**WSCC CONSULTATION RESPONSE:
County Planning – Minerals & Waste Planning Authority (MWPA)**

TO:	Arun District Council Case Officer: Raymond Cole
DATE:	16 April 2021
LOCATION:	Ford Airfield Market, Ford
SUBJECT:	F/5/20/PL - Reconfiguration of Ford Market, including revised market access, hardstanding for replacement vehicular parking and associated infrastructure, landscape, ancillary and site preparation works.
RECOMMENDATION:	☒ Advice ☐ Objection ☐ Modification ☐ No Objection ☐ More Information ☐ Refusal

These comments follow the submission of a revised Waste Infrastructure Statement (WIS) (dated February 2021) prepared by the applicant. They should be read in conjunction with comments made on 2 April and 25 June 2020.

Image 2.2: Proposed Main Car Park Access Arrangement

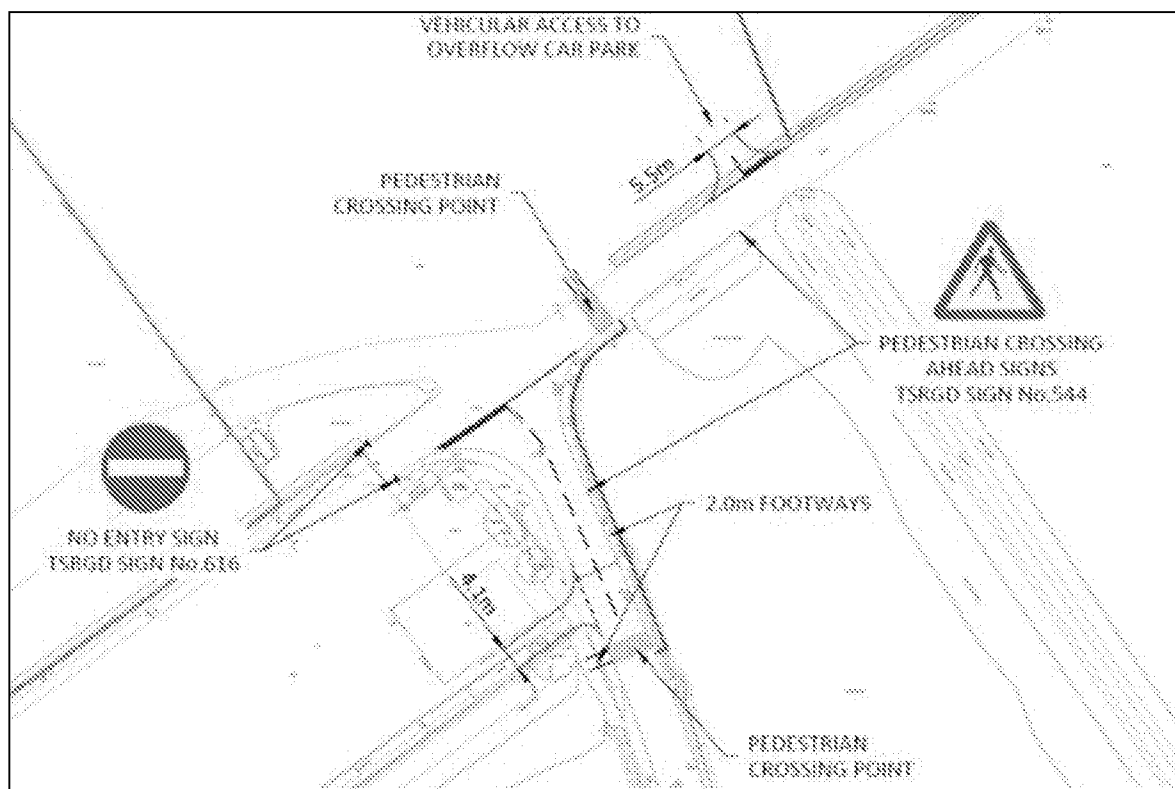
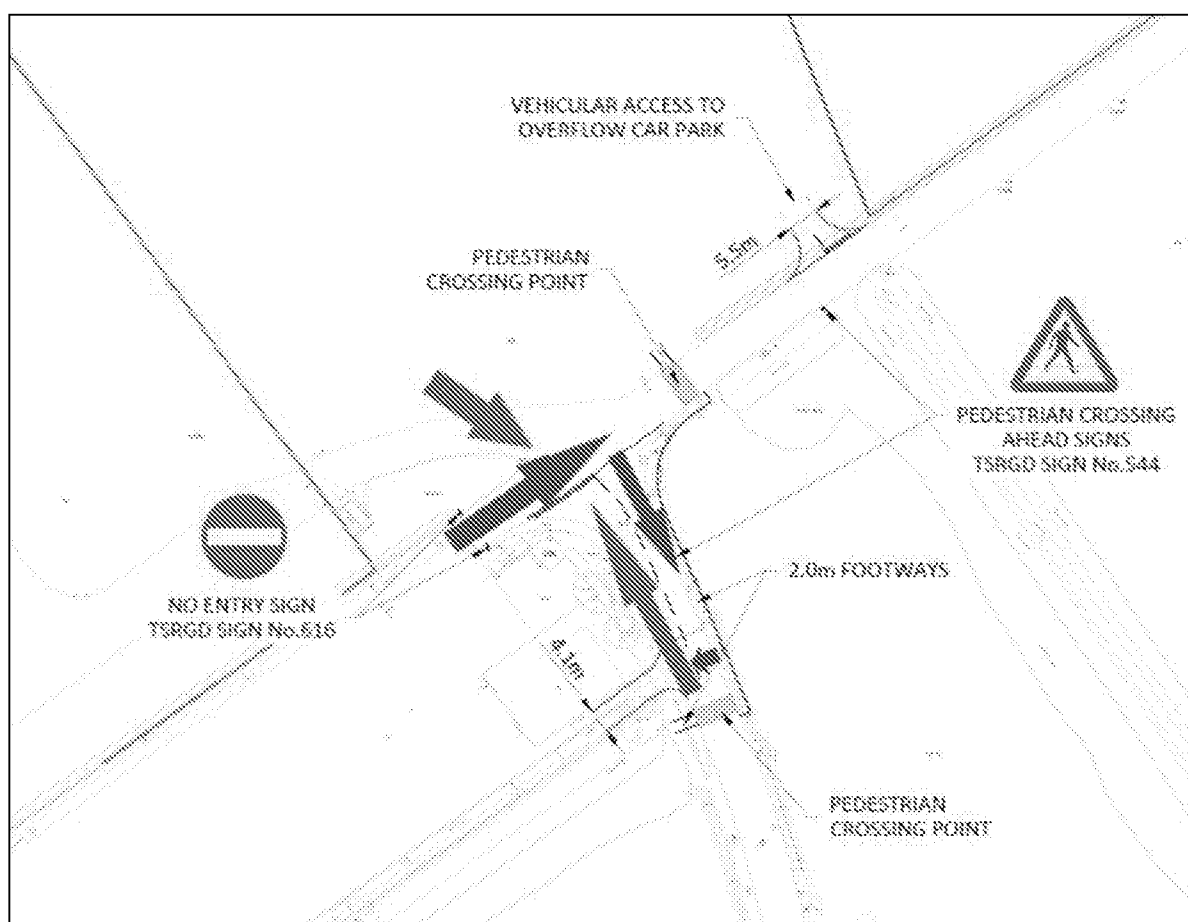
The Technical Note also considers the proposed reconfiguration of site access arrangements at the internal four-way junction serving several existing and allocated waste sites. It concludes that the proposed arrangements would ensure vehicles entering both the market area and overflow car park would be able to proceed immediately, and that priority arrangements would ensure any impediment to waste site traffic would be minimised.

Whilst the MWPA reserve concerns over the potential for some delays to waste site traffic on internal access roads, and note that Transport Assessment modelling suggests a maximum 80 second delay for vehicles exiting onto Ford Road (worst case during peak market times), provided WSCC as Highway Authority raise no further highway safety/capacity concerns, the MWPA do not consider any such impediment to waste site traffic would be considered sufficiently prejudicial such as to warrant objection.

However, to ensure any such impacts are minimised the MWPA would request that, in discussion with the Highway Authority, consideration be given to conditions to secure (1) vehicular layouts and circulation in accordance with the submitted plans, (2) carriageway demarcation as set out in Technical Note paragraph 2.2.4, and (3) a car-parking and pedestrian management strategy.

Image 2.4: Overflow Car Park Traffic Flows

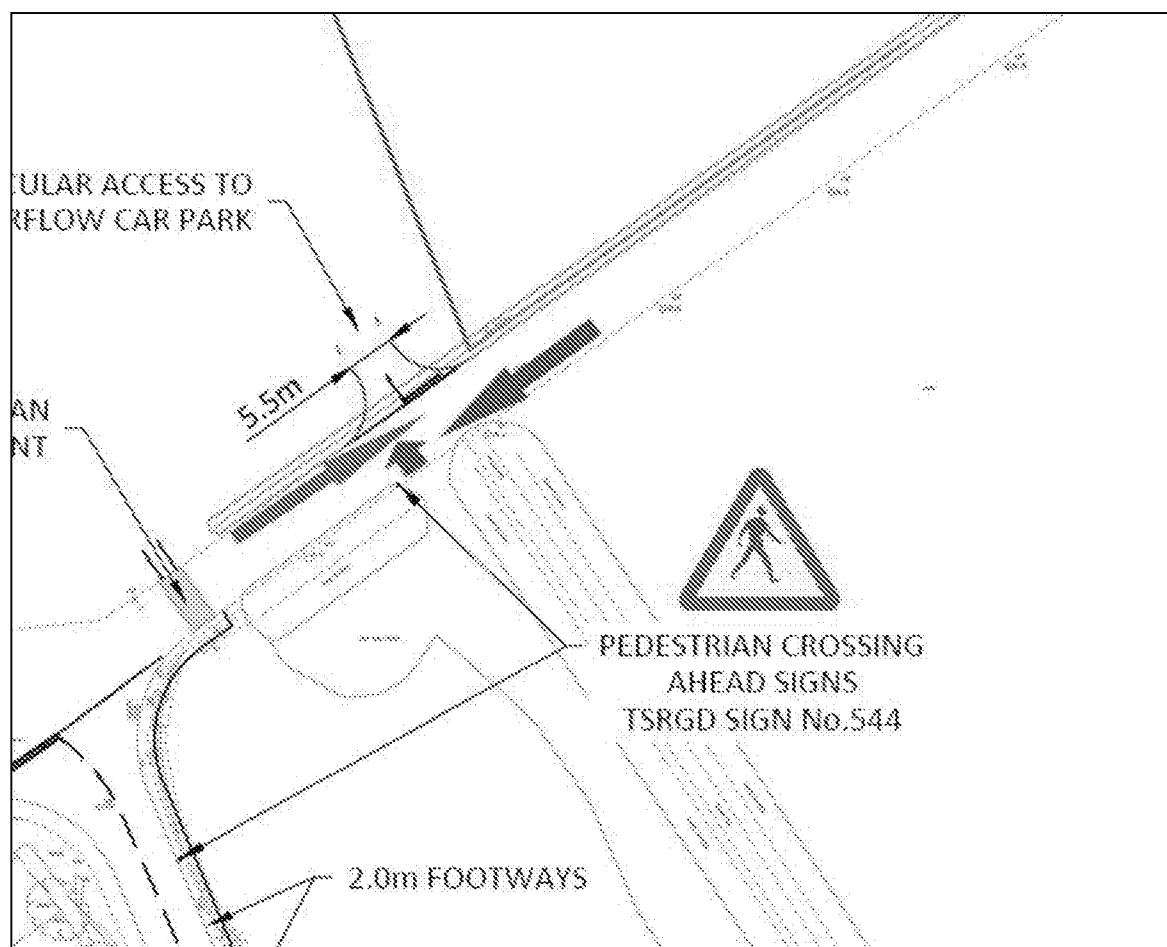
In terms of visual/landscape impacts, the proximity of the proposed overflow car park to the safeguarded CTP site is such that the MWPA reserves some concern regarding the potential for increased visual impacts, in particular the effect of removing a significant section of Mature Poplar trees to the north of the service road, which currently afford valuable screening of the safeguarded CTP site. At present the proposals are for new tree planting alongside the eastern boundary of the overflow car park only.

Nonetheless, given existing boundary treatments, subject to conditions to ensure proposed landscaping is expanded to include boundary screen planting to the north and west (that complements that recently planted as part of WSCC/027/18), the MWPA is satisfied that the proposed development would not prejudice existing and future safeguarded waste sites.
